## Waste Services Consultation Response

Waste Management Officer	X	Head of Eng. Services	X	Refuse & Recycling Manager
Description:	Land at Chatburn Road Clitheroe BB7 2EQ			 Ribble Valley Borough Council <a href="http://www.ribblevalley.gov.uk">www.ribblevalley.gov.uk</a>
Application Ref:	3/2017/0653	Case Officer:	S.K.	
Response Ref:	PMC/11	Issue Date:	28/07/2017

DRAWING TITLE
Site Layout

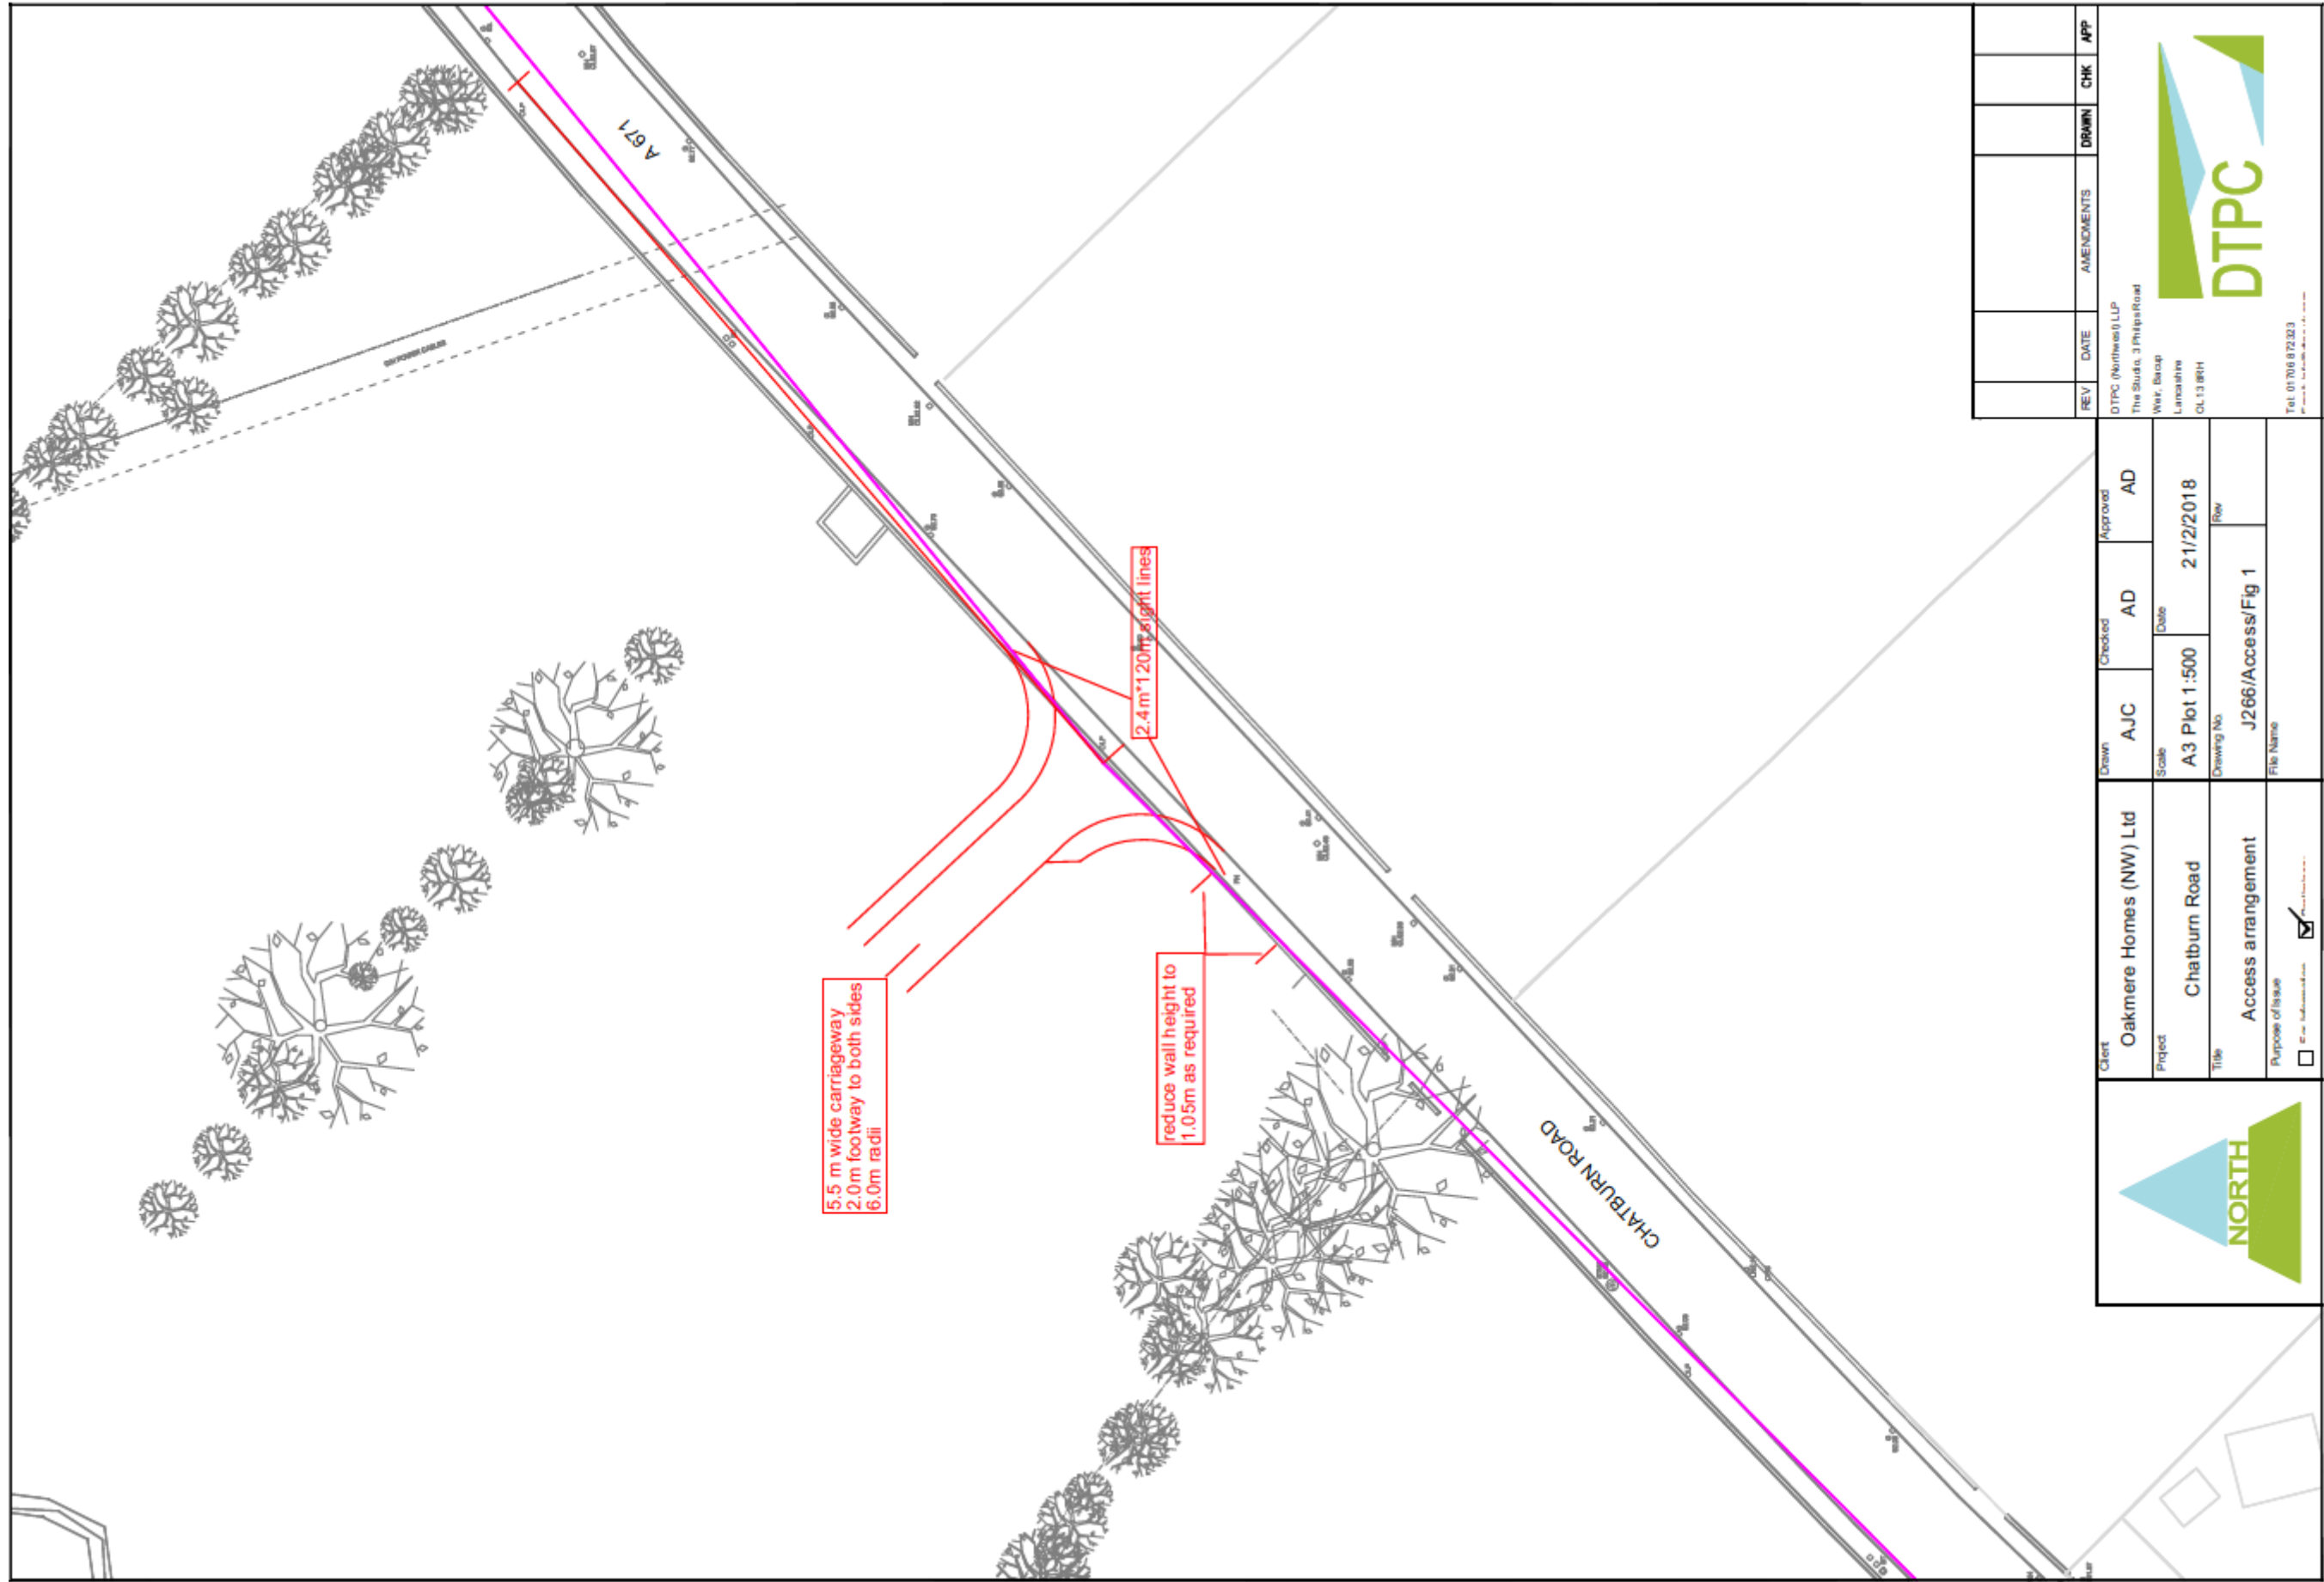
<b>Comments/Observations:</b>						
<b>1.1</b>	<b>Access</b>	<b>Acceptable:</b>	Yes	<b>x</b>	No	
<b>1.2</b>	<b>Issues</b>					
<b>2.1</b>	<b>Manoeuvrability</b>	<b>Acceptable:</b>	Yes		No	<b>x</b>
<b>2.2</b>	<b>Issues. The only issue relating to the development is that there is no turning point for plots 12 – 19 and therefore the collection point for these would be at the junction with plots 18 and 19.</b>					
<b>3.1</b>	<b>Collection/Storage Provision:</b>	<b>Acceptable:</b>	Yes		No	<b>x</b>
<b>3.2</b>	<b>Issues: As above for plots 12 - 19</b>					
<b>4.1</b>	<b>Additional Observations</b>					
<b>4.2</b>	<b>None</b>					
<b>5.1</b>	<b>Conclusions/Suggested Conditions:</b>		<b>Ideally a turning point similar to others provided within the development will allow collection from the curtilage of each property.</b>			
<b>5.2</b>	The above observations have been provided on the basis of the level of information submitted and the comments contained within this response represent officer opinion only, at the time of writing, without prejudice.

<b>5.3</b>	Should you be minded to approve the application, notwithstanding other material considerations, I would suggest that the following conditions be attached should you feel they are relevant and justified: Whilst it has been suggested that the development may be extended from the side of plot 14 and may include turning points the immediate problem remains.					
<b>Officer :</b>	<b>Peter McGeorge</b>		<b>Date:</b>	<b>28/07/2017</b>
